From: Nicola Moore
Sent: 07 October 2020 10:18
To: aruntreeco@gmail.com
Subject: RE: Request for further information AW/267/20/T

47 Kingsway, Craigweil
Private estate. PO21 4DN

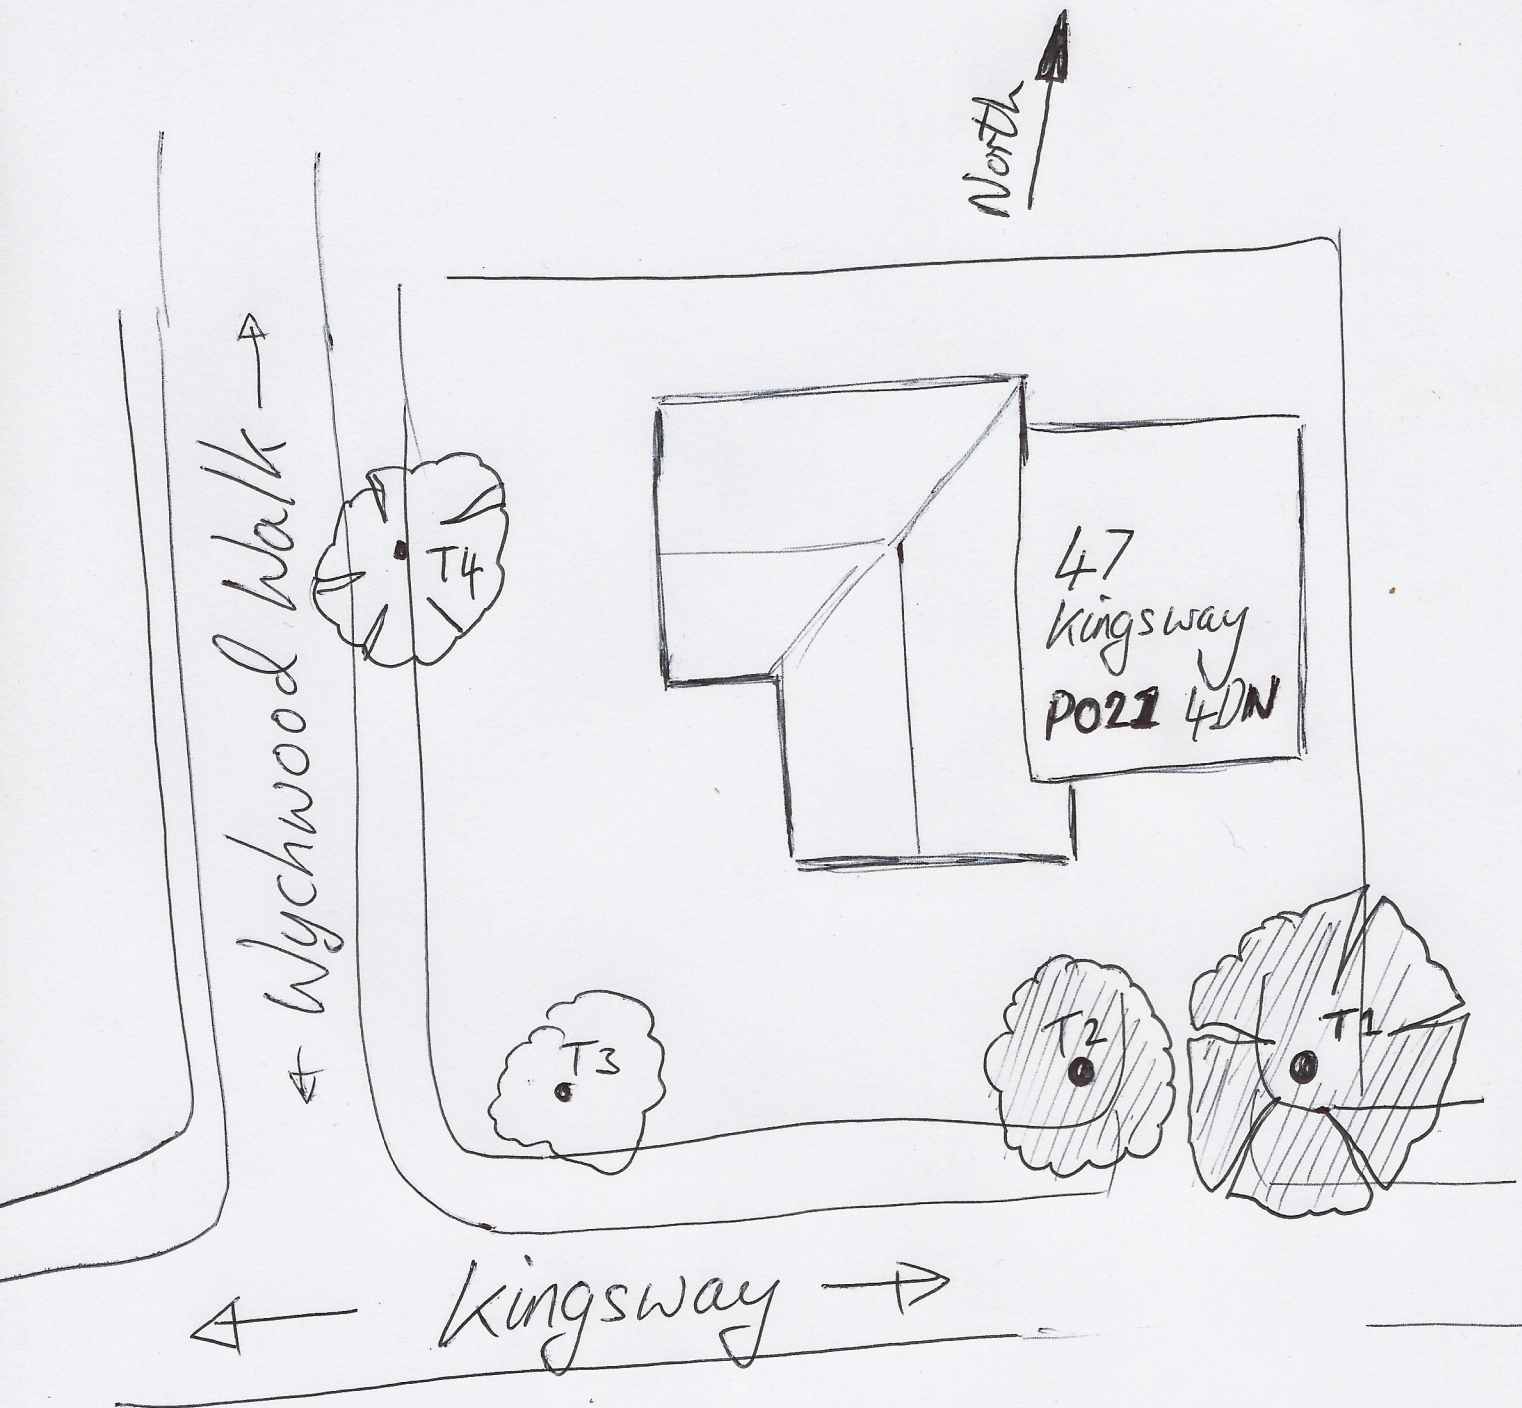
Please could you also clarify the proposed height and spread measurement of T2 – Mature Holly.

I can confirm that the Holly T2 and the Hawthorn T3 did not exist in 1958.

The Proposed Height and Spread measurements are provided in the application and are as follows

T1 Height reduction of 1.5m and spread reduction of 0.5m (estimated final height 10m and final total spread 6m)

T4 Height reduction of 1.5m and spread of 0.5m (estimated final height 8m and final total spread 5m)
